From: Ian Wightman [REDACTED]
Sent: 31 October 2012 10:43
To: Peter Mullans
Cc: Janice Chapman; Martyn White
Subject: RE: Replacement windows. BE13712L (ADC)

RE: listed building application BE13712L (ADC)

re: Application for listed building consent BE13712L (ADC)

Photograph of front elevation of house, which faces west, showing the windows.
Scale approx 1:50 at A4

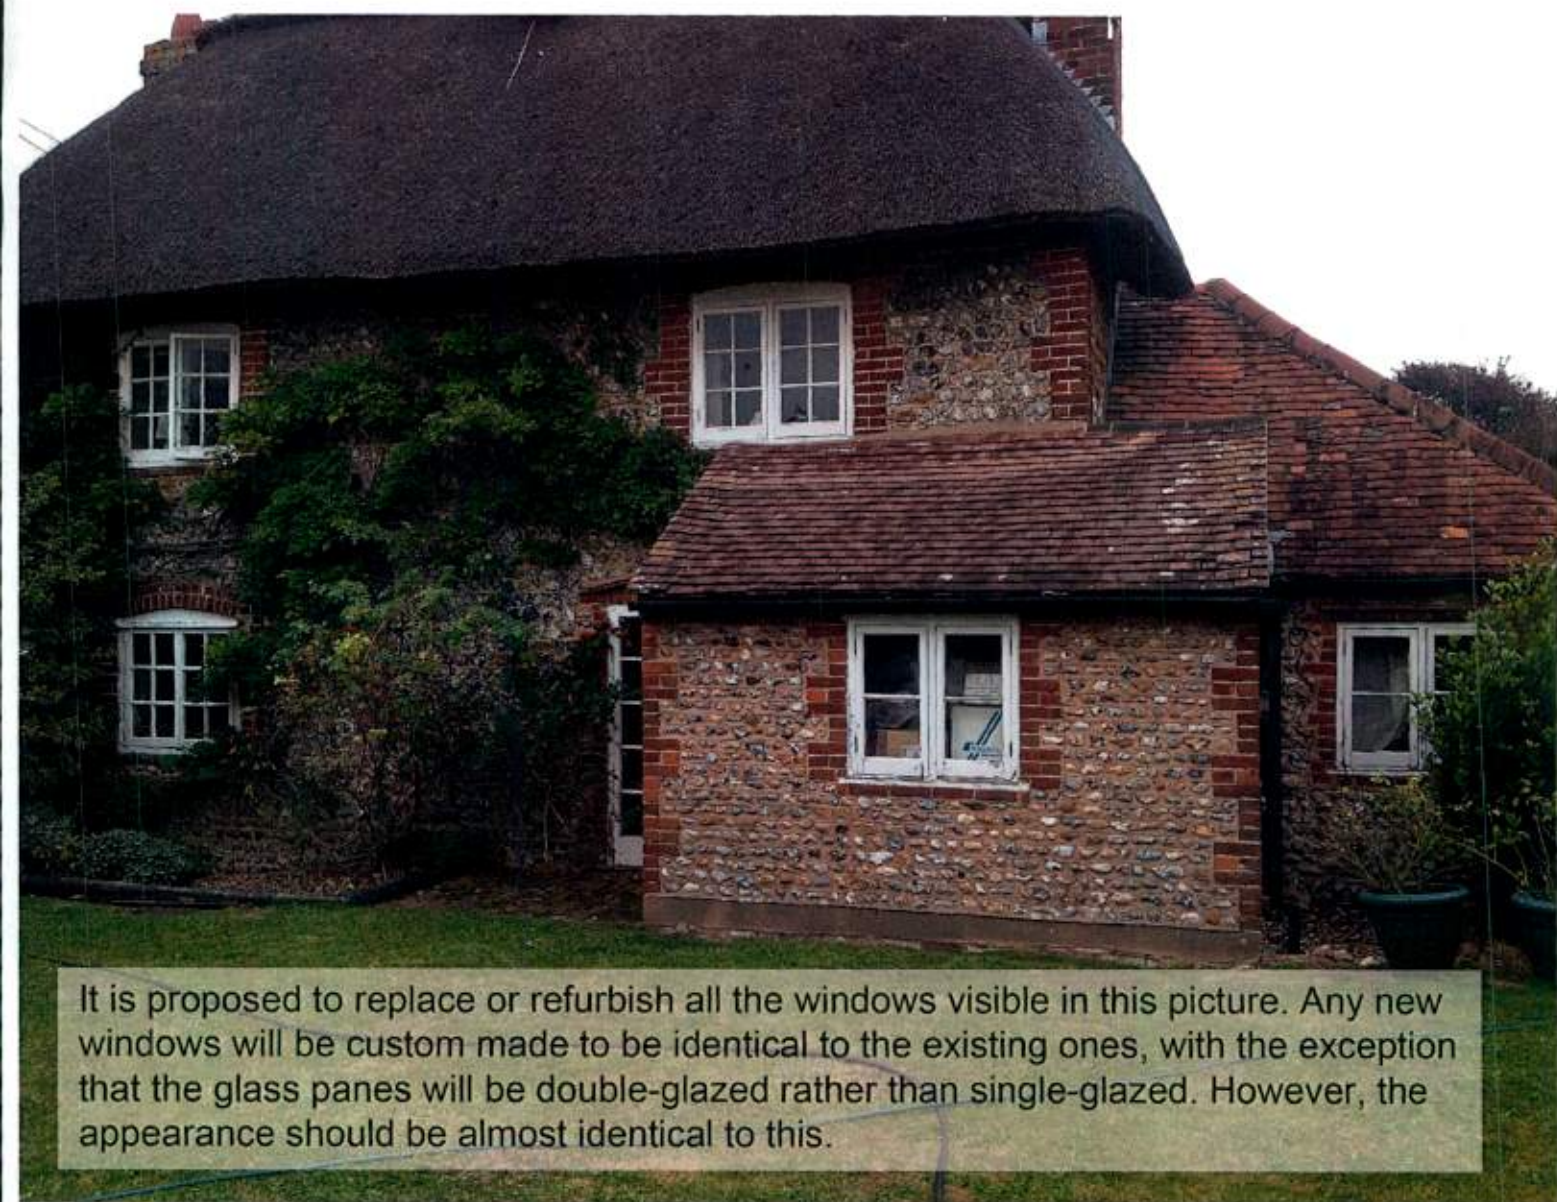
Thank you for your email. Whilst I appreciate your view, single glazing is fundamental to the integrity, character and appearance of an historic building. Once replaced with double-glazing the building's special interest and character is severely compromised and the appearance harmed. This is not normally acceptable for most listed buildings which are of course statutory protected. There are exceptions to this, but these are usually structures which require large areas of glazing such as conservatories and in some cases barn conversions. For most domestic buildings with normal fenestration there are very few.

Secondary glazing is considered largely acceptable because it does not interfere with the integrity and fabric of the building. It is a fitting like a curtain and can be easily removed without causing long term damage. Secondary glazing does vary in quality and appearance, but has improved significantly. It also reduces draughts, which double-glazing does not necessarily do.

The fact that your windows cannot be broadly seen, is not a consideration in this case. The value of a building's appearance and setting is not determined by its public amenity. As mentioned above, it is the historic integrity of the building that we seek to maintain and enhance where possible.

I would be very grateful if you would be kind enough to have another look at this application and perhaps reconsider your advice. I would ensure that the replacement windows were identical, in terms of the depths and widths of glazing bars, rebates, transoms, etc, and of course would submit samples (or dimensioned diagrams where samples are not practicable). So the only difference would be in the glazing, and there would be minimal change in the appearance of the glass, in terms of its reflective qualities, as the glass in the existing windows is modern flat plate glass.
